**KIRKLEES METROPOLITAN COUNCIL
INVESTMENT & REGENERATION SERVICE**

**DELEGATED DECISION TO DETERMINE APPLICATIONS FOR
CONSENT, AGREEMENT OR APPROVAL REQUIRED BY CONDITION**

Reference No:	2024/44/92857/W
Site Address:	Carters Barn, Hollins Lane, Slaithwaite, Huddersfield, HD7 5JE
Description:	Discharge of details reserved by condition 2 (access and parking) on previous permission 2024/91244 for part change of use of dwelling to convert bedroom into gymnasium to facilitate personal training sessions
Recommending Officer:	Molly Storer

DECISION – DISCHARGE OF CONDITION APPROVED

Directions and Parking Instructions

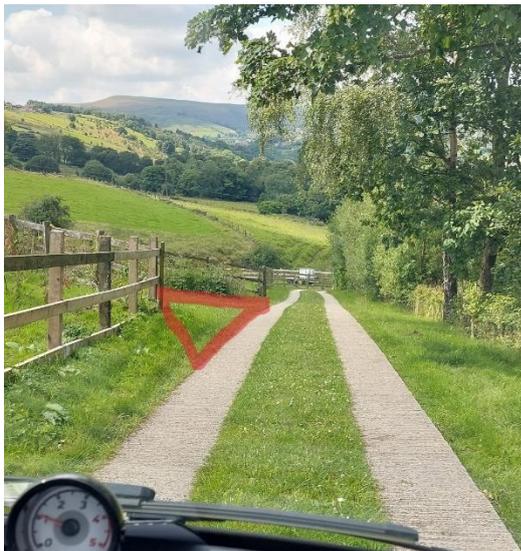
However, plans submitted as part of this application do not show this access to be in place and instead show the main access to still be to the south east and north west of the site. It is considered that this will have a harmful residential impact as previously set out in the officer report and which was the reason for the inclusion of condition no.2 of the permission. Access arrangements previously indicated to be utilised, to the north east of the site and which would have a lesser impact in this regard are considered to be an alternative arrangement which would have an acceptable impact with regard to the reason for condition no.2.

Part e of the condition requires a management plan to ensure access by non-resident users of the gym training facilities is via that as permitted by part a of this condition. The submitted management plan shows the access route the guests will be required to take to access the gym training facilities. It also states that 'To ensure that this access route and parking area is used, all personal training clients (new and existing), will be issued with written instructions on how to access the property which will include photographs

showing where the entrance to the access/drive is, and where to park, to ensure that all clients only use this permitted access only.' This is considered to be acceptable.

With regard to part f (signage to ensure access is taken in accordance with that as permitted by parts a and c of this condition) a plan had been submitted to show that there will be clear signage directing clients to the parking area which will be placed at the entrance to the drive/access to the parking area – location marked with a green cross/annotated on the plan. Signage will state “Parking for Personal Training Clients ” with the arrow directing them to the right, into the drive/access to parking area. There will also be a “Personal Training Client Parking” sign in front of the parking space – location marked with a green cross/annotated on the plan. This is also considered acceptable

SITE PLAN 1:500

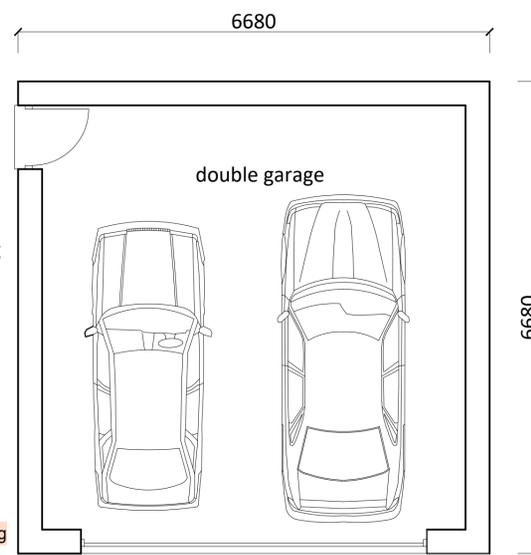
Condition 2 cannot be discharged at this time as the submitted scheme sets out an access to the site located to the south east and north west of the site. The proposed access would have a harmful impact upon residential amenity of neighbouring occupiers contrary to the reason for the condition and in particular as a result of associated noise, nuisance / disturbance within a private domestic area, contrary to policies LP24 and LP52 of the Kirklees Local Plan.

The new scheme which has been submitted shows a separate driveway to the east/southeast of the Barn to avoid visitors to the gym having to access the site around the neighbouring property. It is considered that using the access as set out in drawing 01RevA would ensure there was not a significant degree of noise and nuisance to sensitive receptors at the northwest elevation of the neighbour. This is considered to be sufficient information to address part a (access and associated parking to the site to be used by all non-resident visitors utilising the gym training facilities) and part d (areas dedicated for parking for use of the gym training facilities by visitors).

With regards to part b (details of surfacing to the access and parking area) the submitted plan shows that the turning area/Personal Training Client Parking area (bordered orange on the attached plan) will be surfaced in gravel, using a plastic reinforcement system, in accordance with section 3 page 12 of [Guidance on the permeable surfacing of front gardens](#) Ref: ISBN 9781409804864 Reinforced Gravel. The drive/access to the parking area (bordered green on the attached plan) will be surfaced using wheel tracks – two concrete strips, in accordance with section 3 page 11 of [Guidance on the permeable surfacing of front gardens](#) Ref: ISBN 9781409804864 Wheel Tracks. This is considered to be in keeping with the original drive to the rear of Carters Barn/Farm as shown on the photo provided. This is therefore considered acceptable.
